Arun District Council Planning Objections

Having just examined the planning applications Numbers LU/221/14/PL -222 -223 -224 – and 227 with prefix and suffix the same, the writer would comment as follows.

Figure 1.2: Development Site Layout

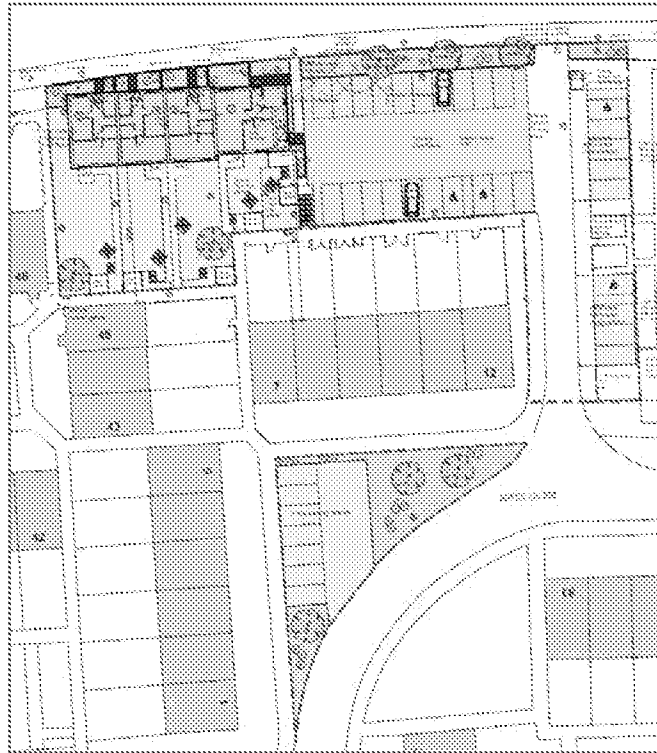
There are no indications on the drawings, as to the positioning of dropped kerbs to the roadways and footpaths as to allow easy access/egress of wheelchairs and other disabled mobility vehicles to the new housing, or widths of any new alleyways to show that they conform to new housing disability regulations.

As there is a short distance from a number of the proposed houses north elevations, up to the dog walk, what provision is being made to ensure easy and safe access/egress for the disabled to use the external doors, to compensate for the different elevations?

The drawings also give no indication as to if level ground, to the south elevation entrance doors are to be in place.
